Application for a non-material amendment following a grant of planning permission.

EP/27/10/NMA

DEMOLITION OF EXISTING BUILDINGS AND ERECT 21 NO. NEW DWELLINGS, ACCESS, PARKING & PROVISION OF PUBLIC OPEN SPACE AT FORMER REDUNDANT NURSERY SITE.

EP/95/08

drawing no
5326/L(04)002 H
revision
H

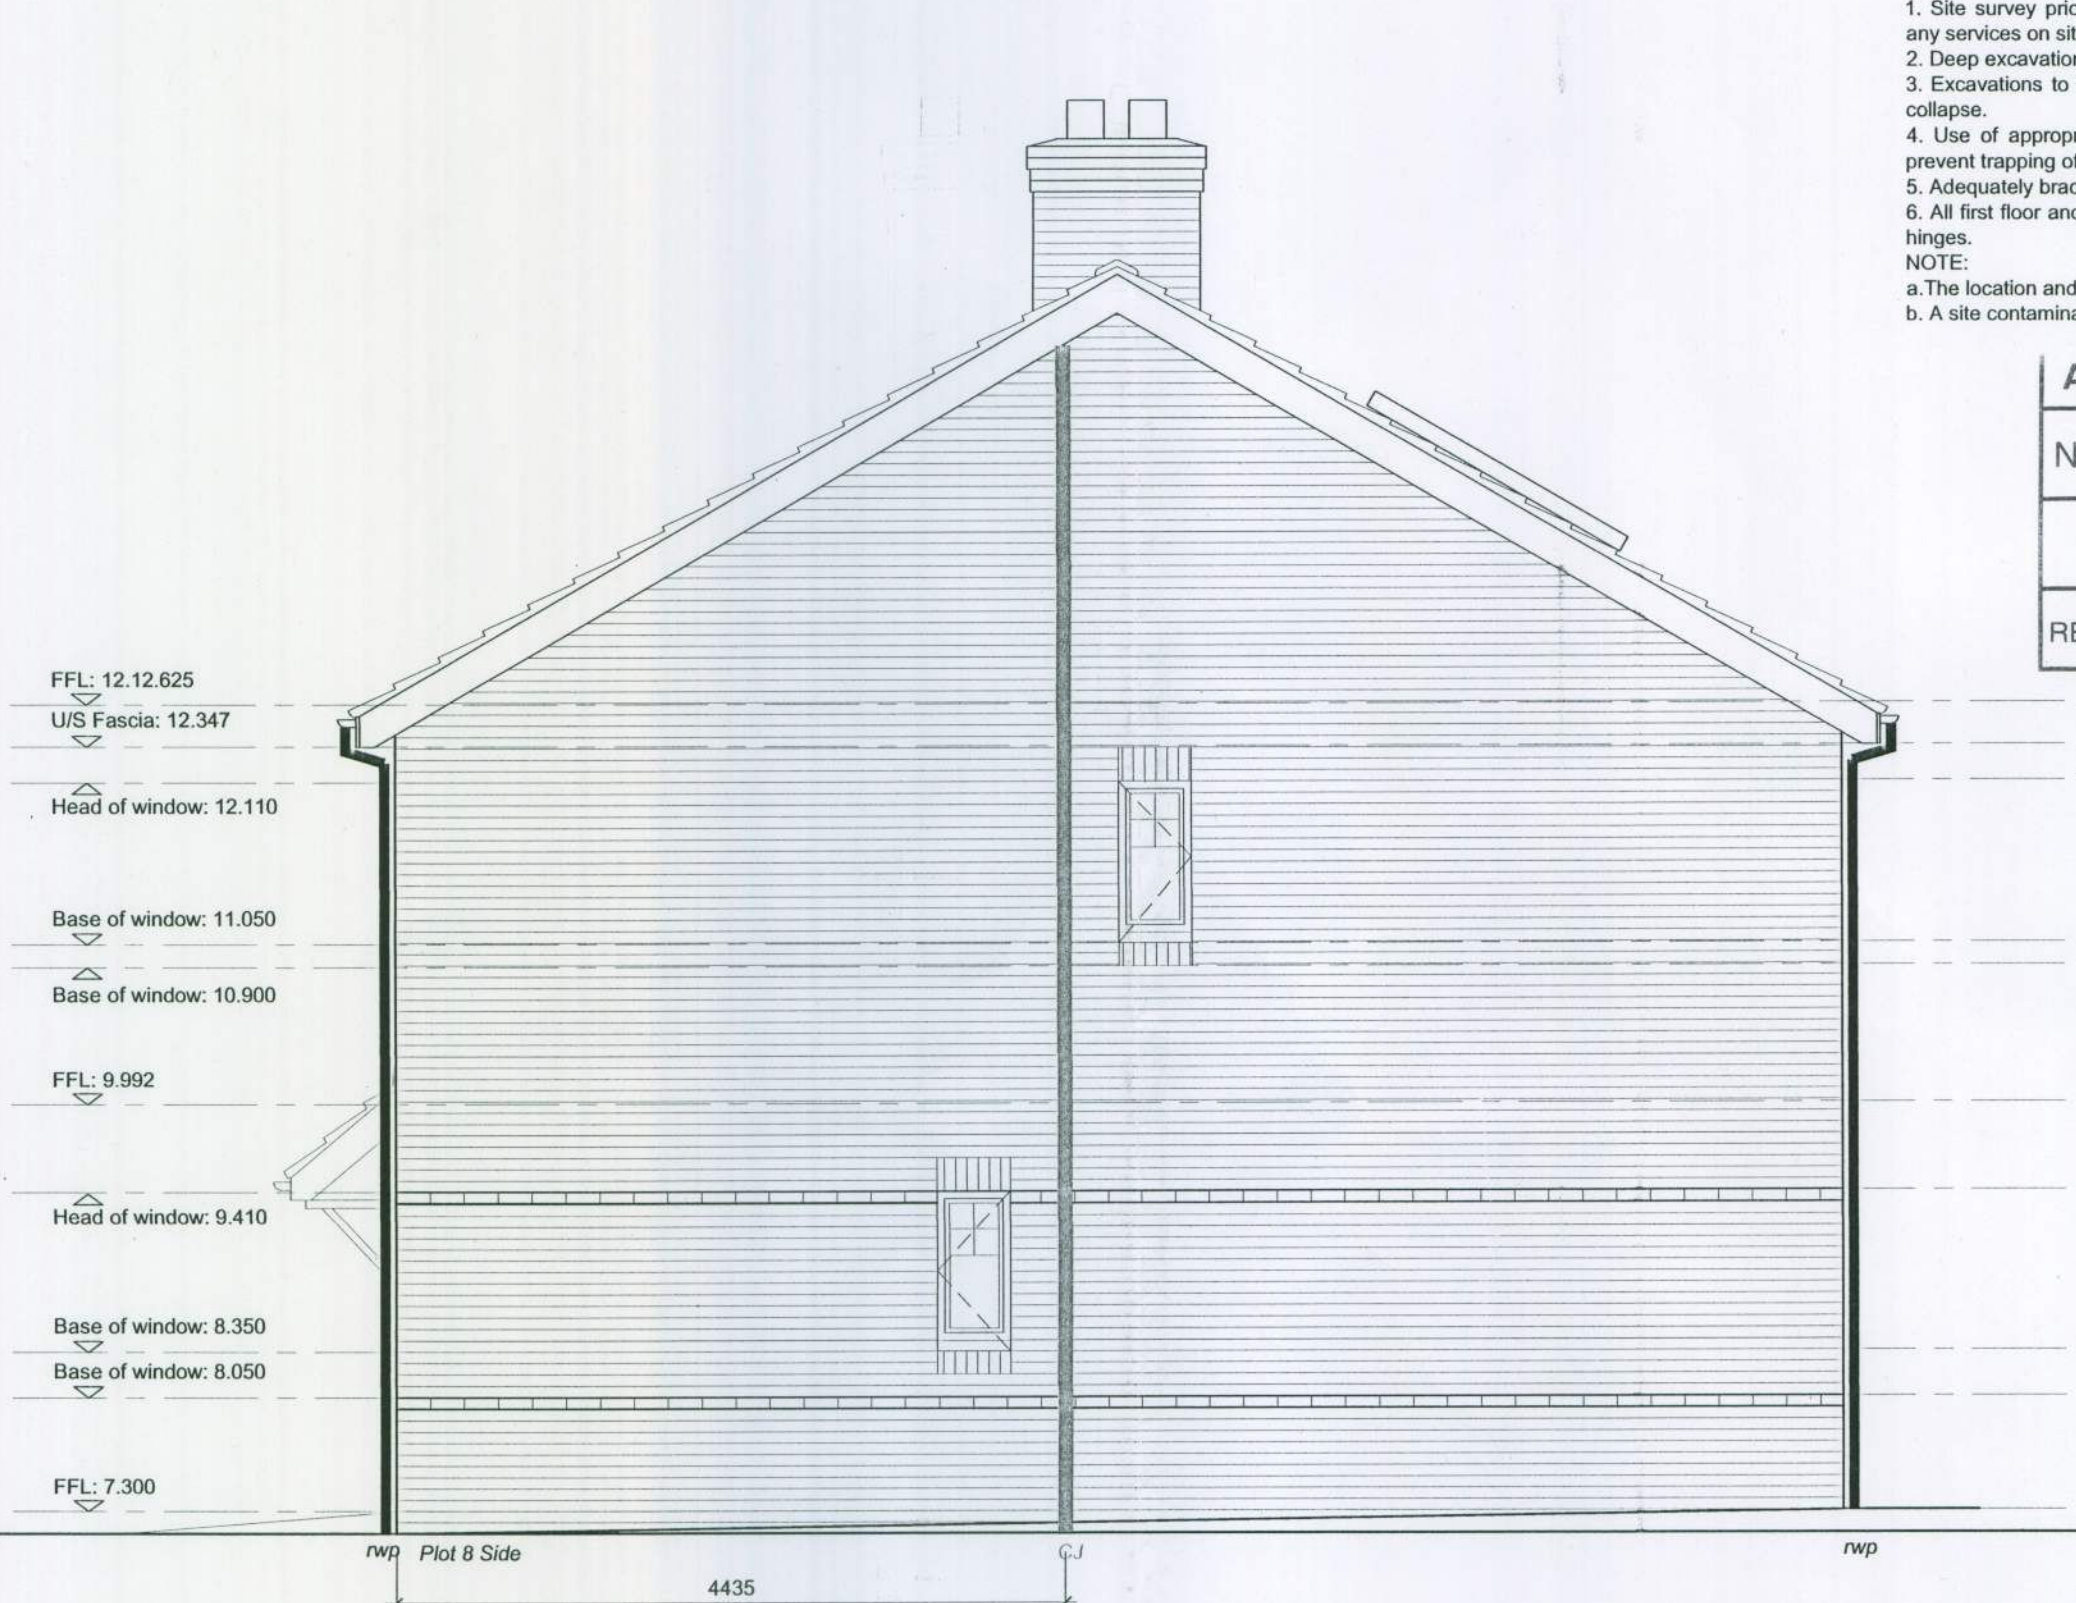
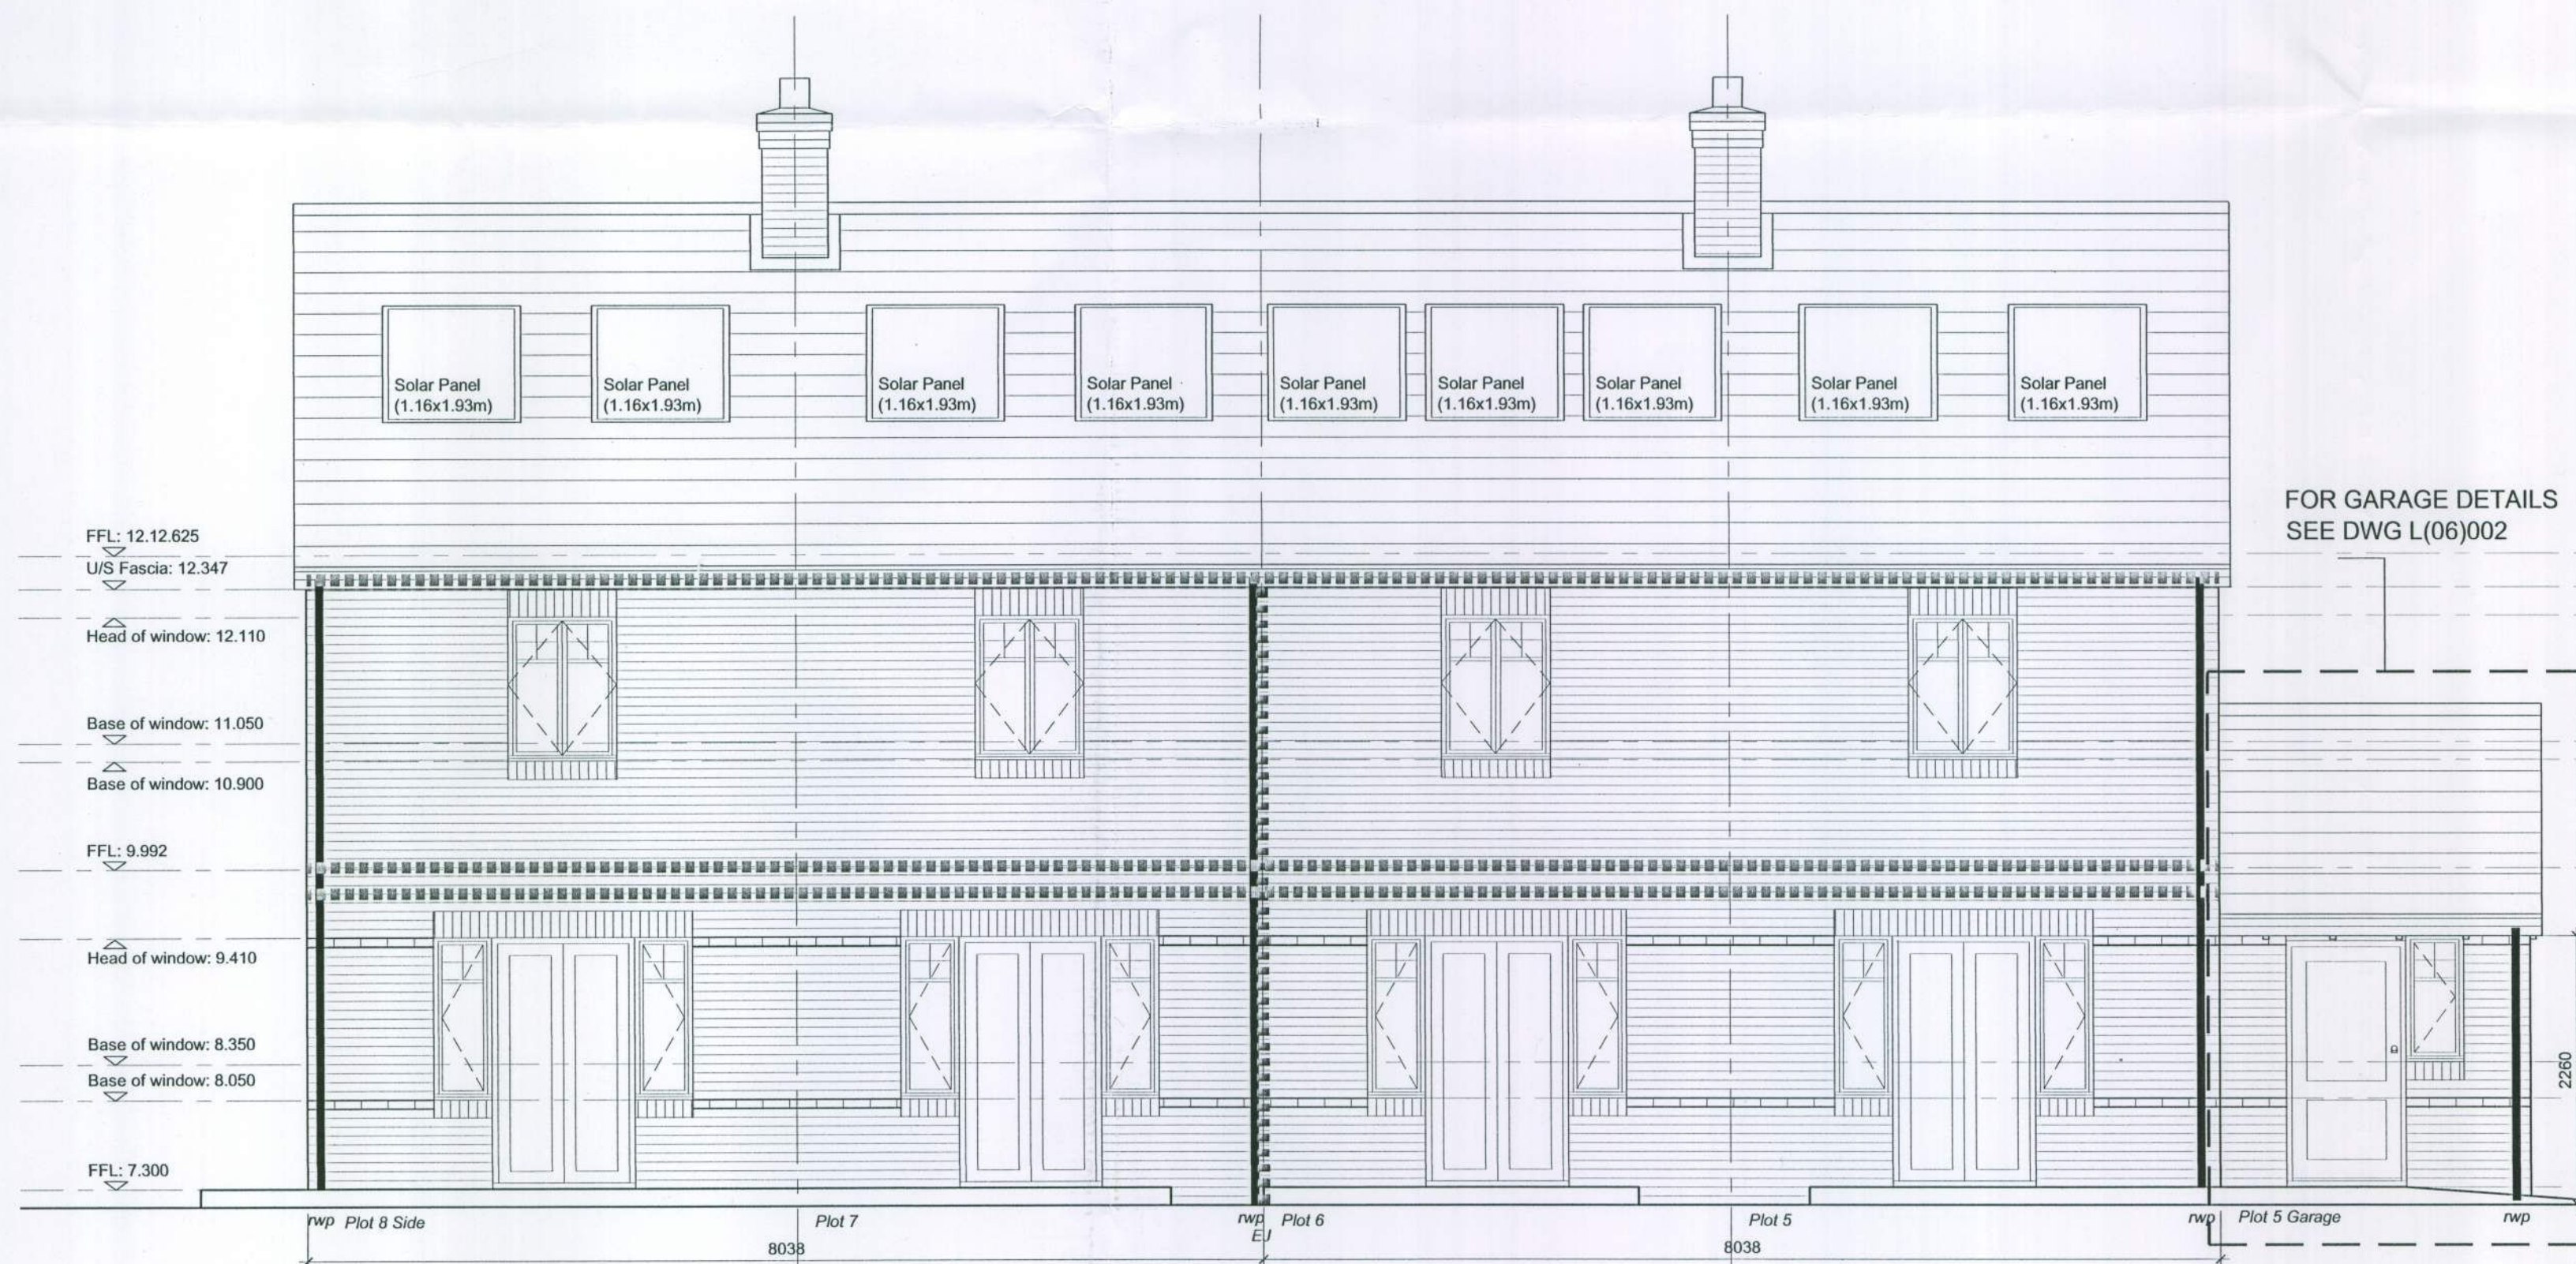
1. TO OMIT THE GALLOWS BRACKETS SHOWN ON THE EAST ELEVATION AT FIRST FLOOR BOTH SIDES OF THE GABLE WINDOW
2. TO REVISE THE CHIMNEY DESIGN FROM THOSE SHOWN ON THE APPROVED DRAWINGS TO THOSE INDICATED ON OUR PROPOSED CONSTRUCTION DRAWINGS.

1. THE GALLOWS BRACKETS ARE CURRENTLY DETAILED AS BACKING ONTO TILE HANGING, IT WILL BE VERY DIFFICULT TO INSTALL THESE GALLOWS BRACKET WITH TILE HANGING FINISHING NEATLY INTO BOTH SIDES OF THE BRACKET.
2. WE WISH TO VARY THE DESIGN OF THE CHIMNEYS ON THE APPROVED PLANNING DRAWING & INSTEAD CONSTRUCT THE CHIMNEYS AS DETAILED ON OUR CONSTRUCTION DRAWING.
